**CITY OF PORTLAND, MAINE
 DEVELOPMENT REVIEW APPLICATION
 PLANNING DEPARTMENT PROCESSING FORM
 DRC Copy**

2004-0099
 Application I. D. Number
 5/21/2004
 Application Date
 110 Ledgewood St. Peaks Island
 Project Name/Description

RE: Application for Minor Site Plan, 110 Ledgewood Street, Peaks Island
(CBL#087E002) (ID#2004-0099)

**SITE PLAN**

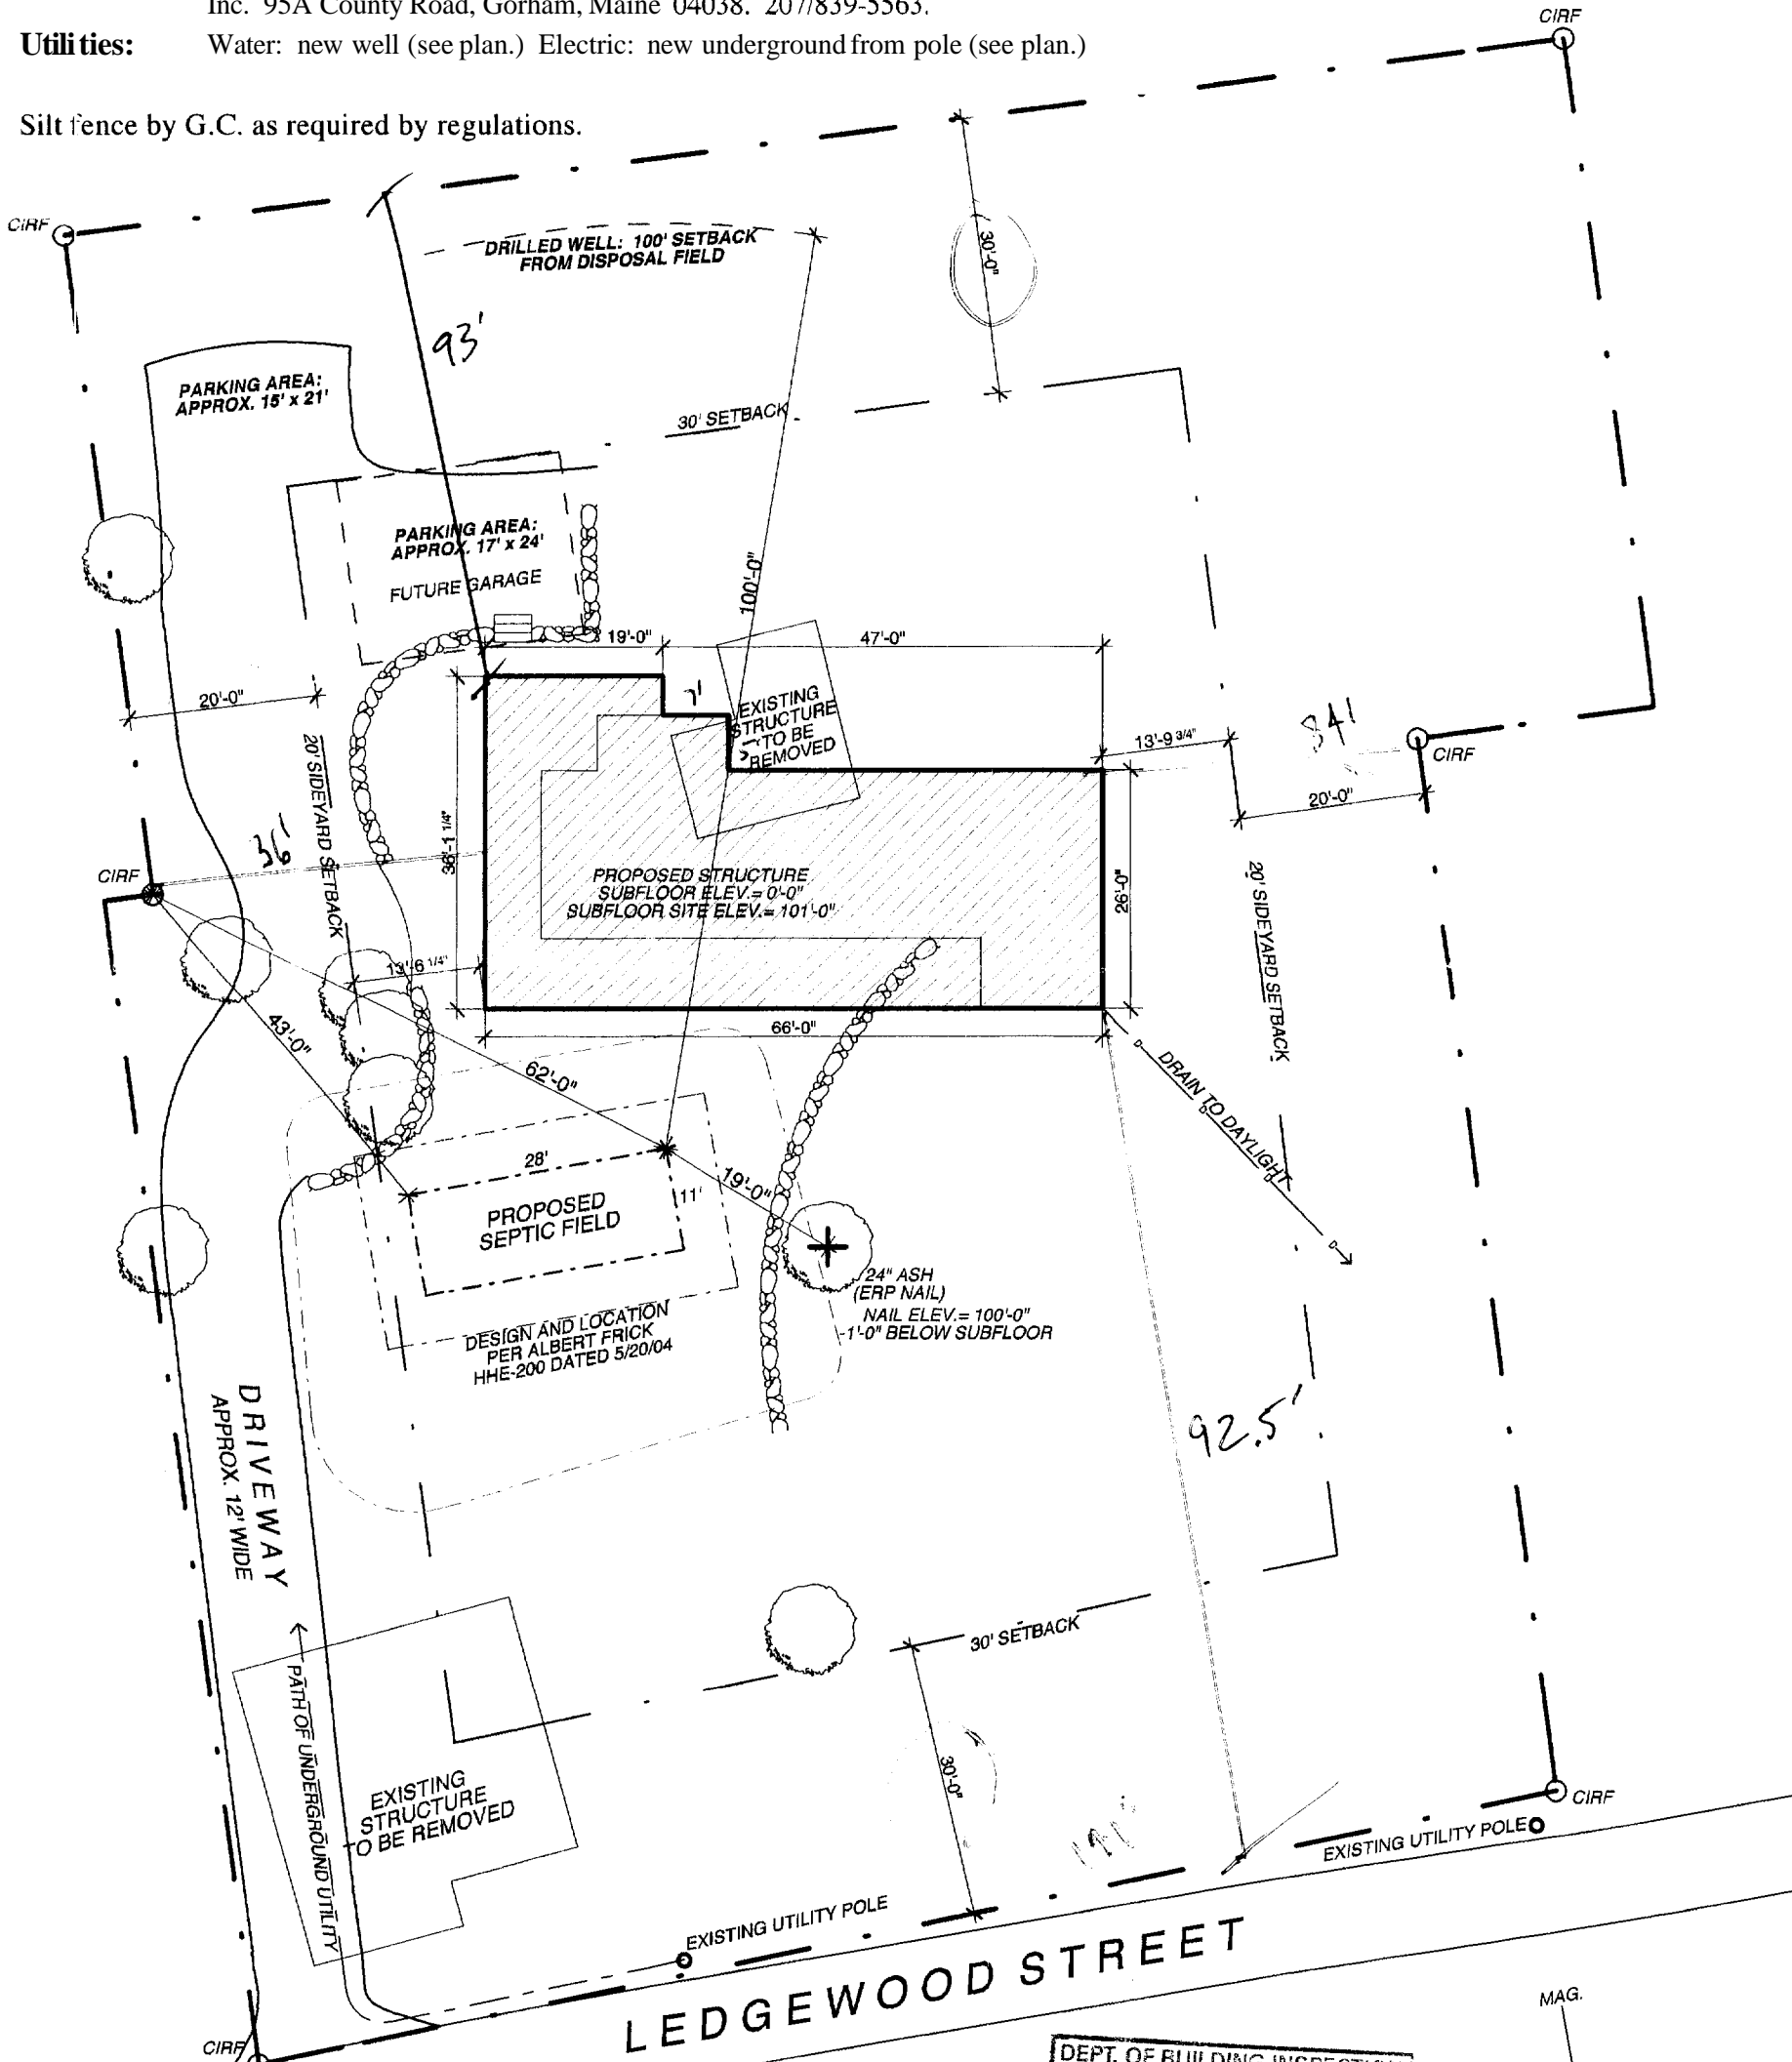
1. Please re-locate the proposed driveway so the apron does not encroach on the abutting property.
2. Please show silt fence/erosion control in its' appropriate locations on the site plan.
3. It appears that drainage, both existing and proposed, travels easterly. In order to prevent any drainage issues with the neighboring property, it is recommended that a dry well be installed at the outlet of the foundation drain.
